Planning Applications

- 1.1 Change of Use to office/business (B1) and Financial and Professional Service (A2). Application No 2012/0328
- 1.2 A meeting was held on 14.03.2012 to discuss the above application together with the case officer Steve Kirkham and the historic buildings officer Tony Wiles.

- 2.1 Listed Building Consent, Internal Alterations
Application No 2012/0333/INVALID

Project: FORMER COUNTY COURT BUILDING 12 REGENTS STREET, BARNESLEY		Client: LUDY'S SOLUTIONS
Drawing Title: FIXED FURNITURE REMOVED PLAN		Date: MARCH 2012
Scale: 1:100 @A1		Dwg. No. 01
Rev. 01

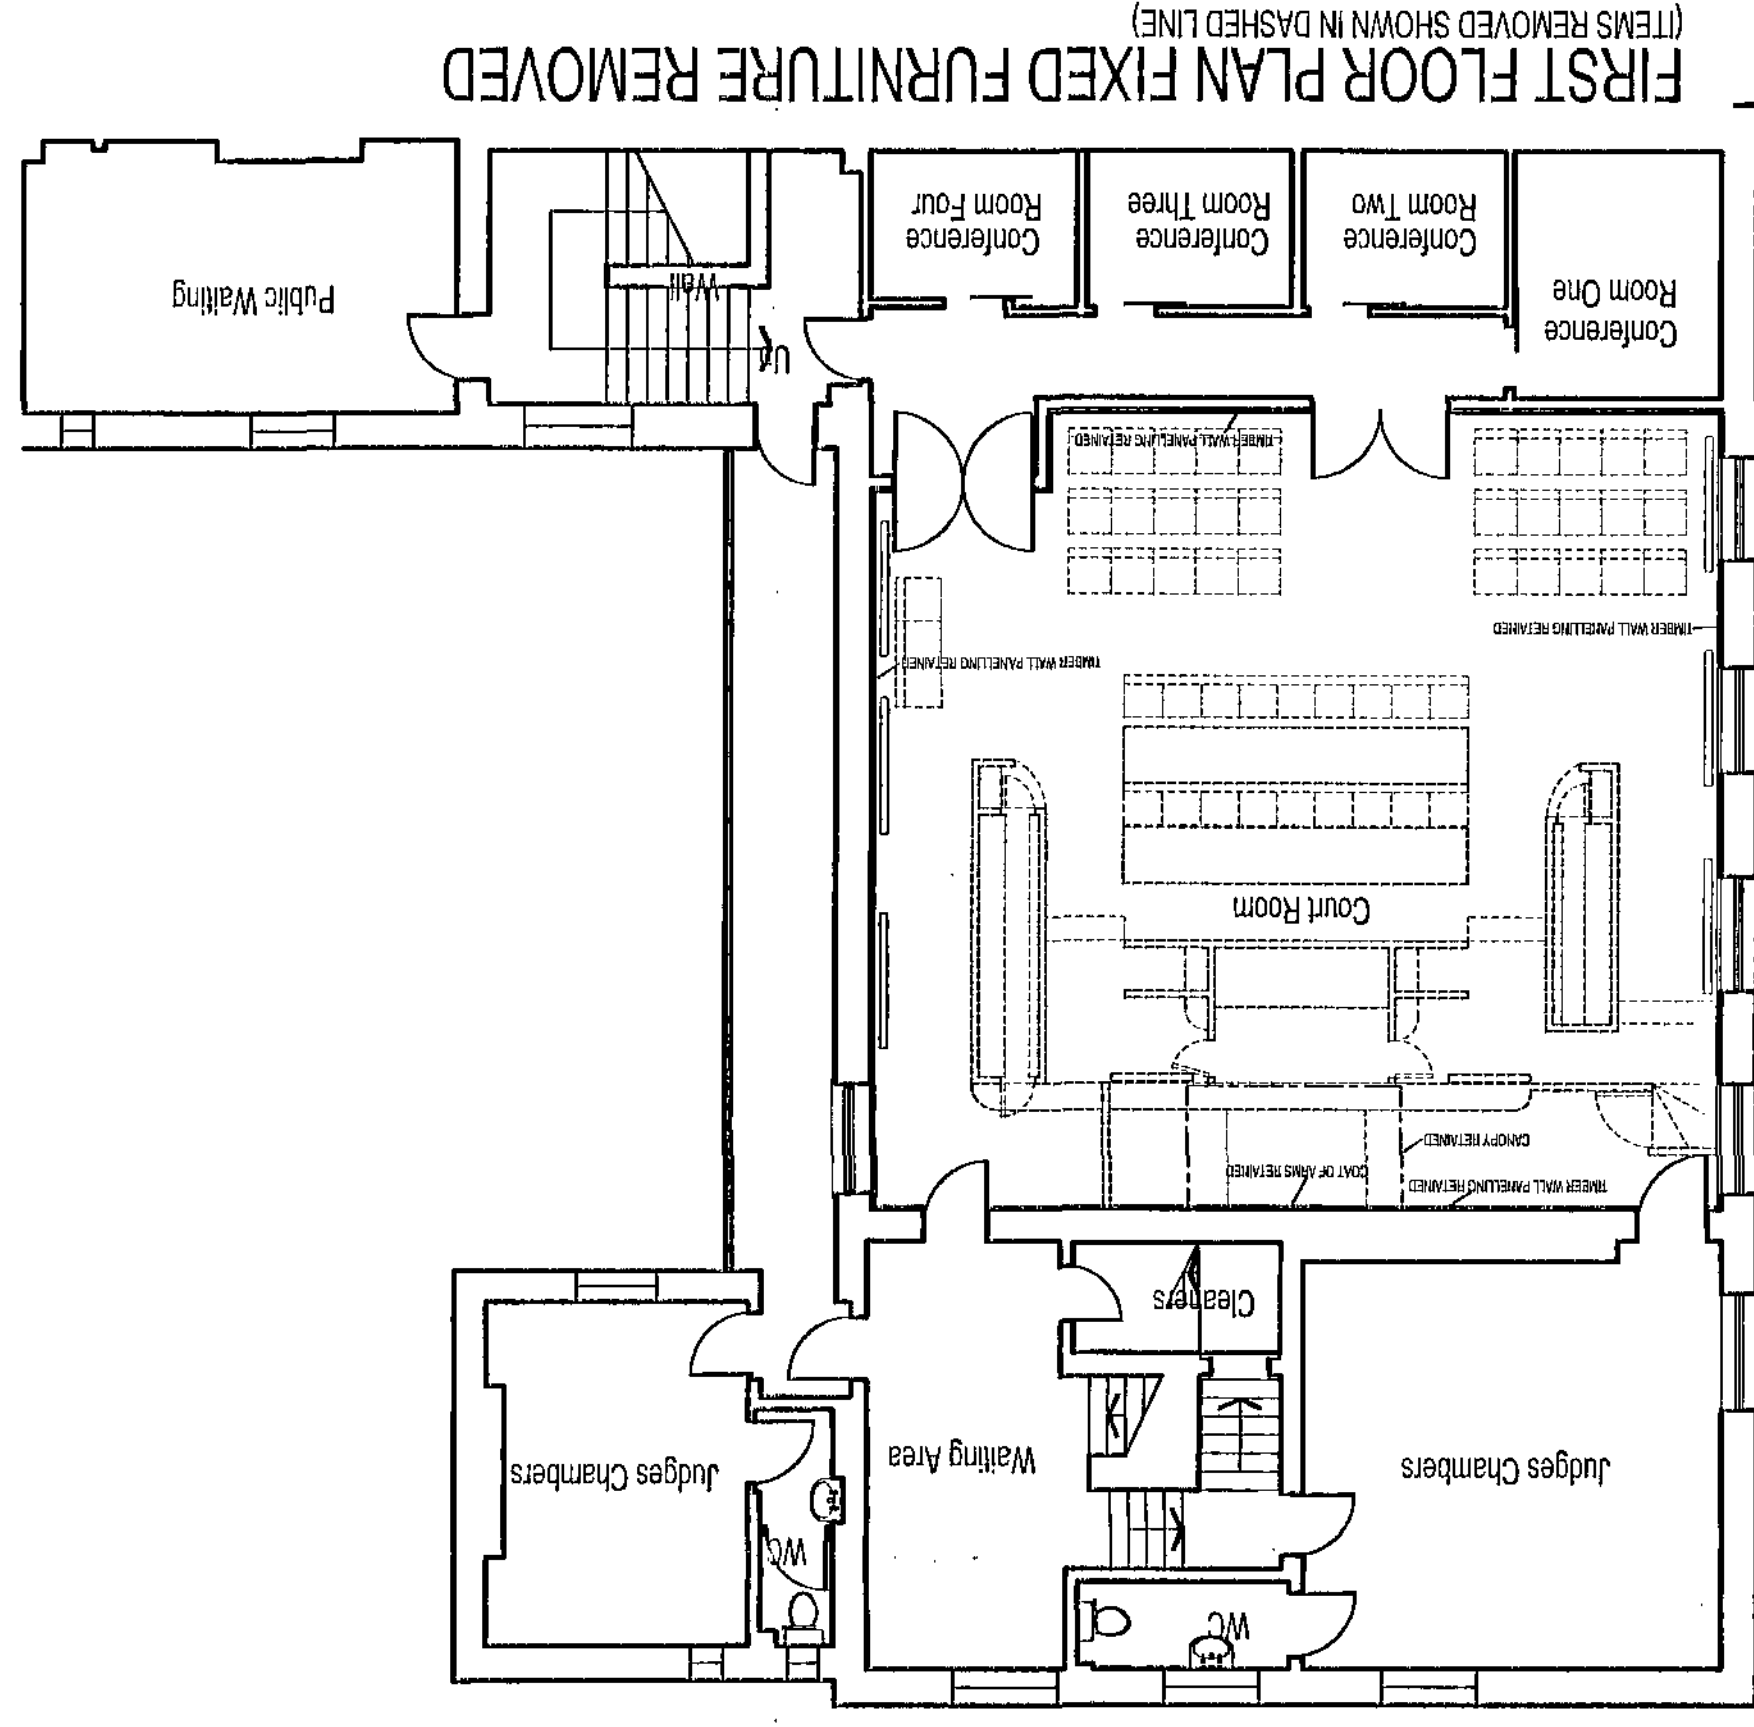
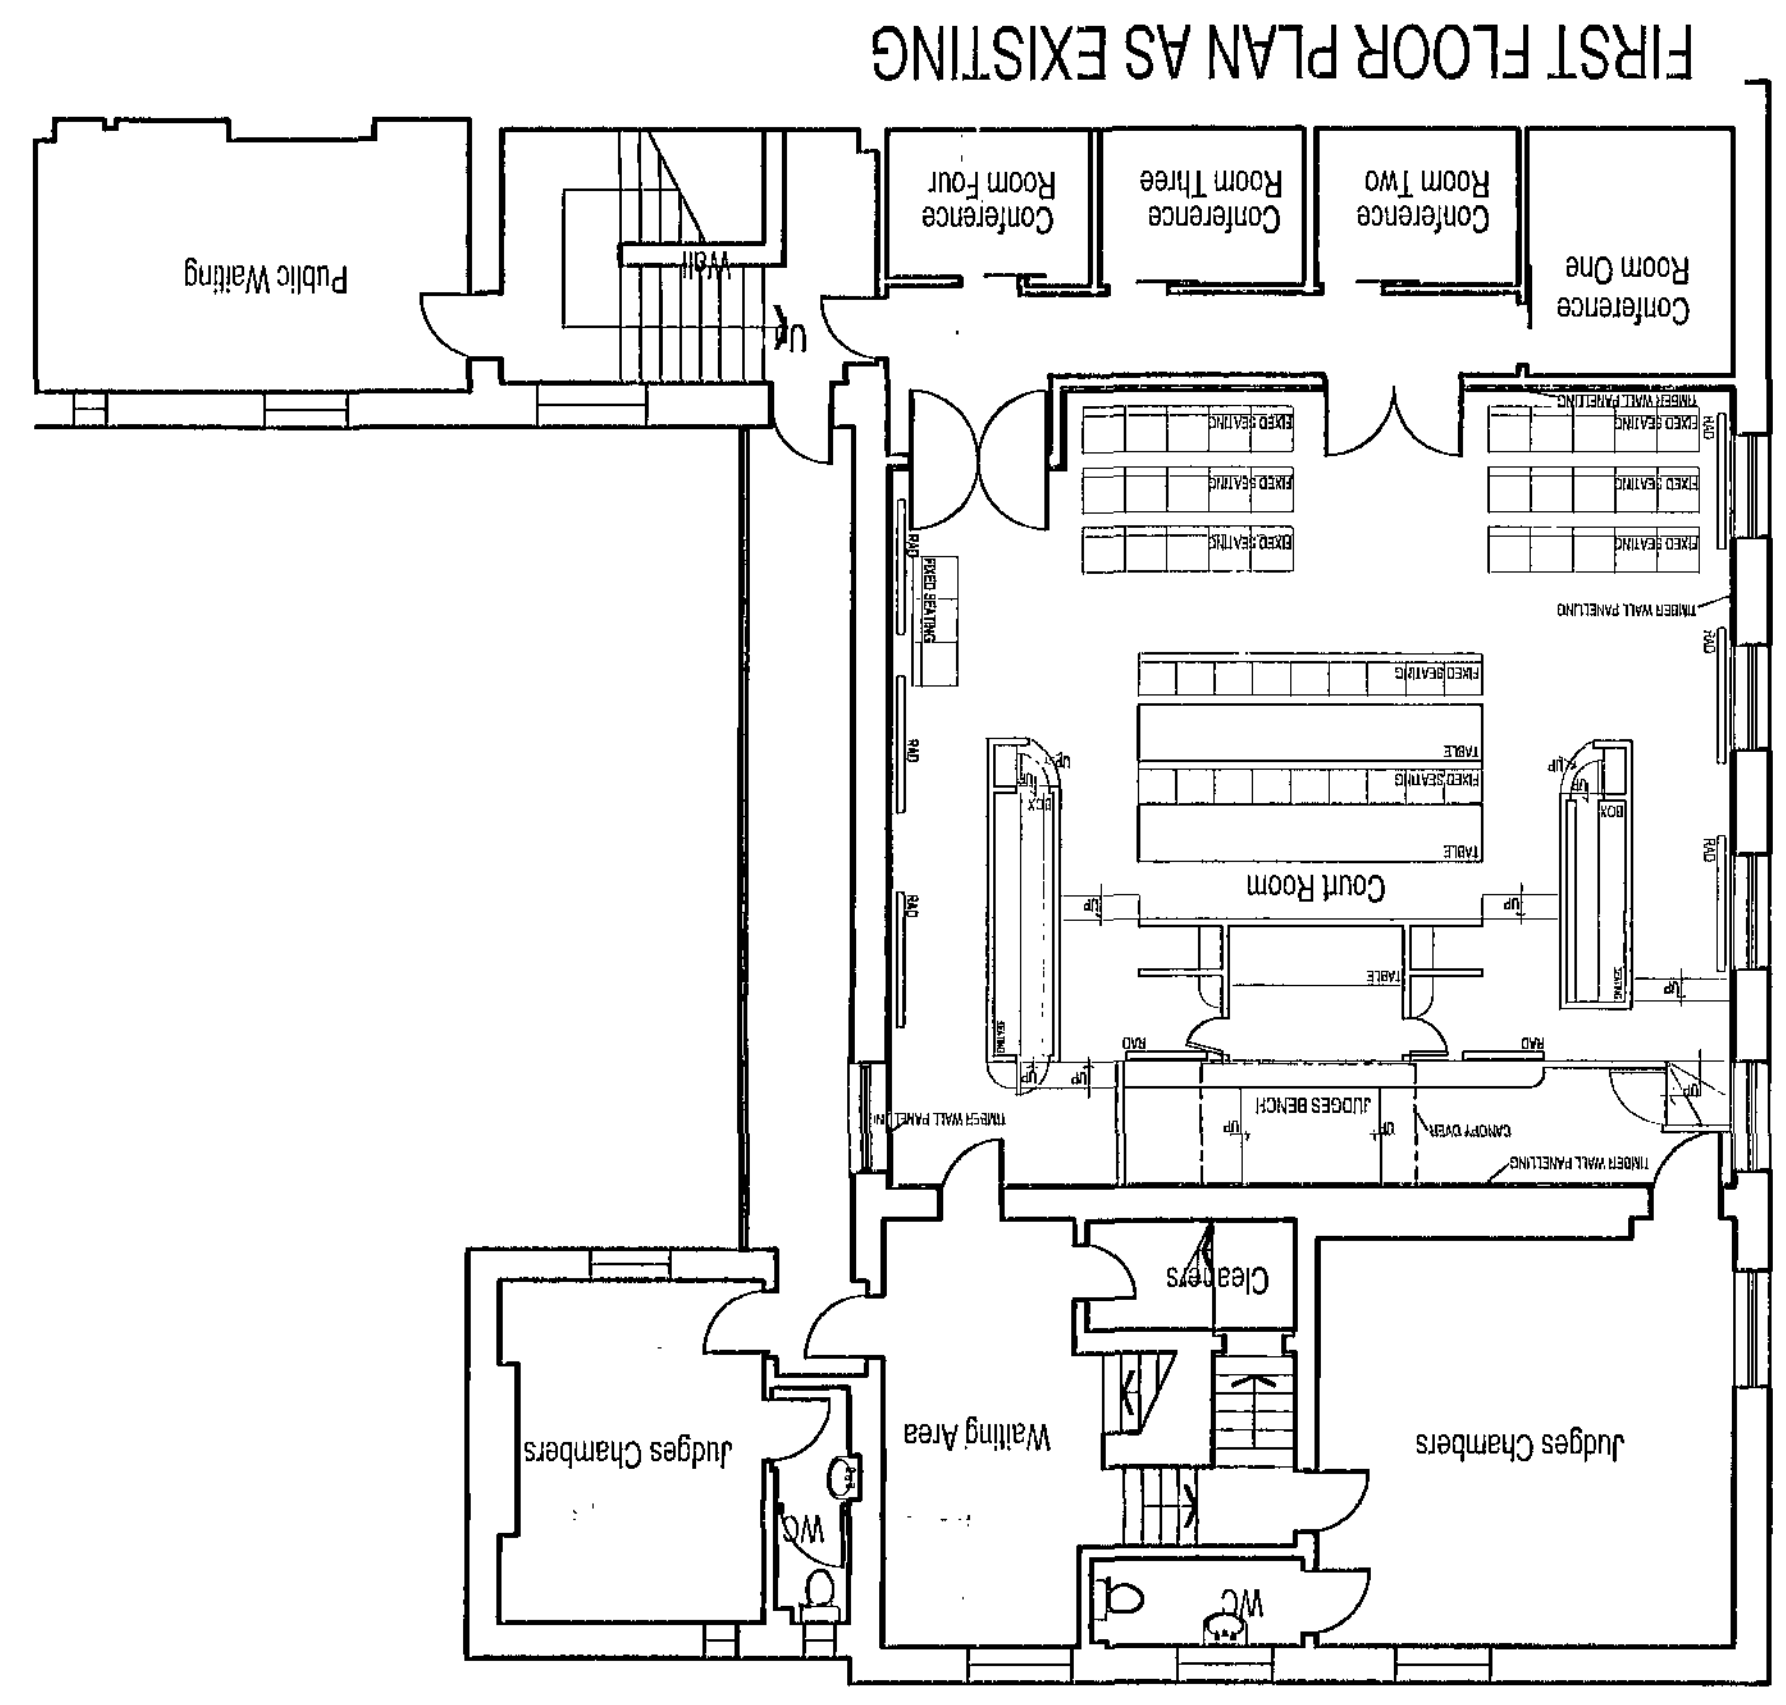
2.4 Further plans are to be prepared and submitted to show the changes to the fixed furniture (removal) within the courtroom and the removal of raised floor levels.

Dwg Title: PROPOSED FLOOR PLANS

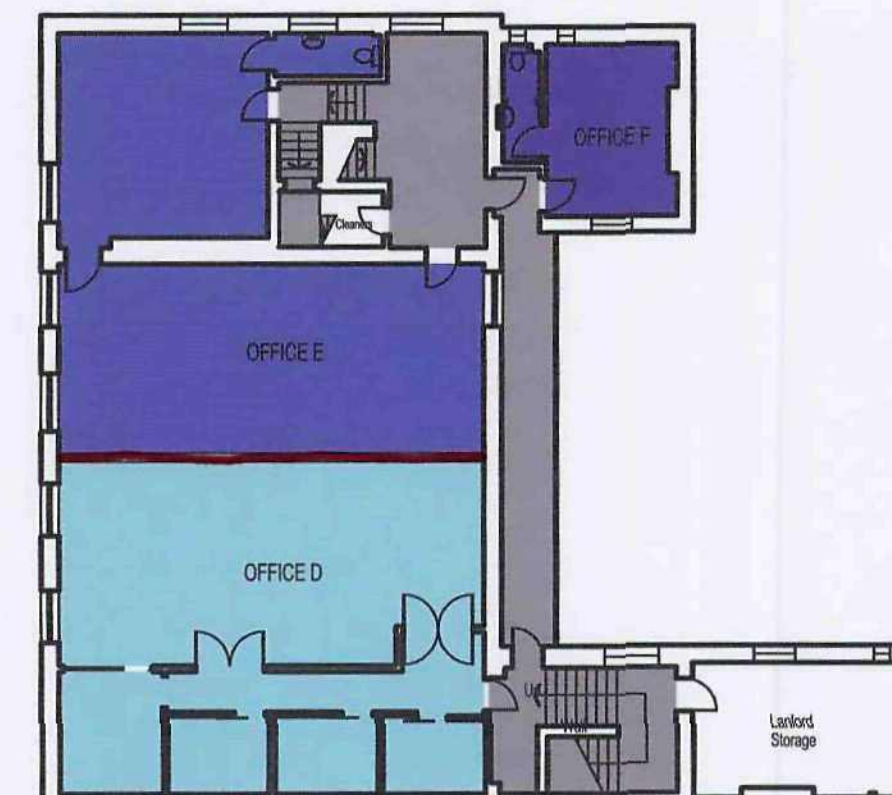
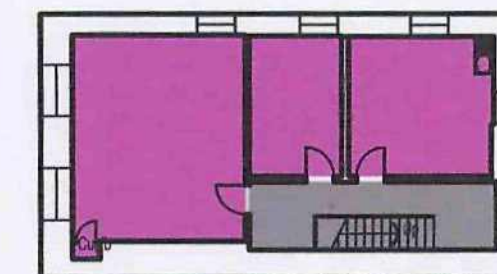
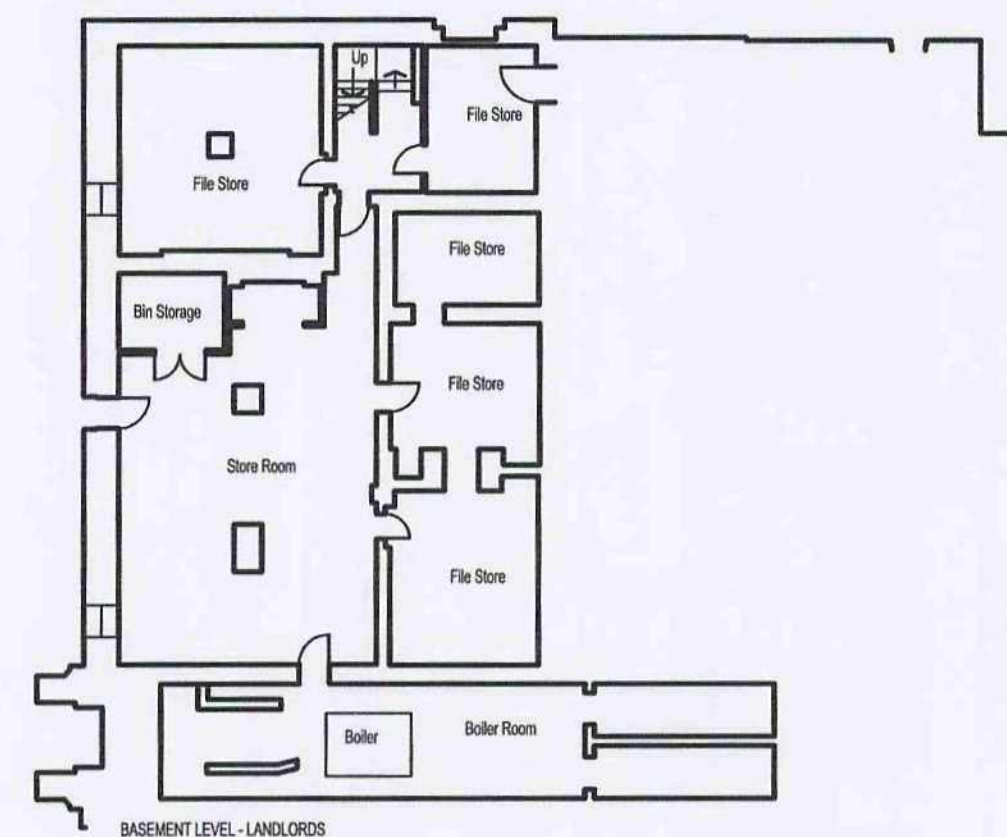
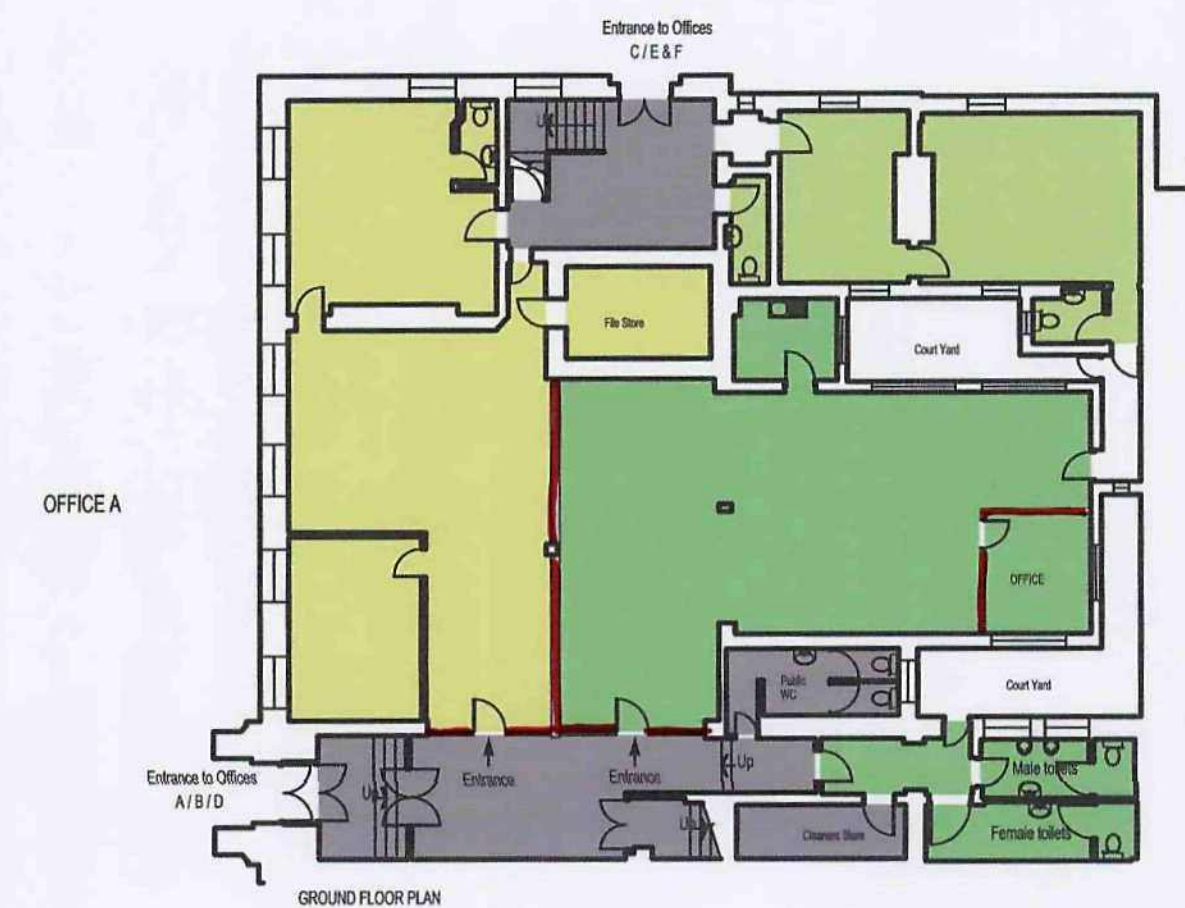
The alterations to partitions at ground floor level, replacing the existing counter arrangement and the proposed new division centrally located across the courtroom would not affect any original features. Further details are to be provided but in principle no listing issues are involved. The court plaque and the canopy and panelling behind the Judge's desk can be retained.
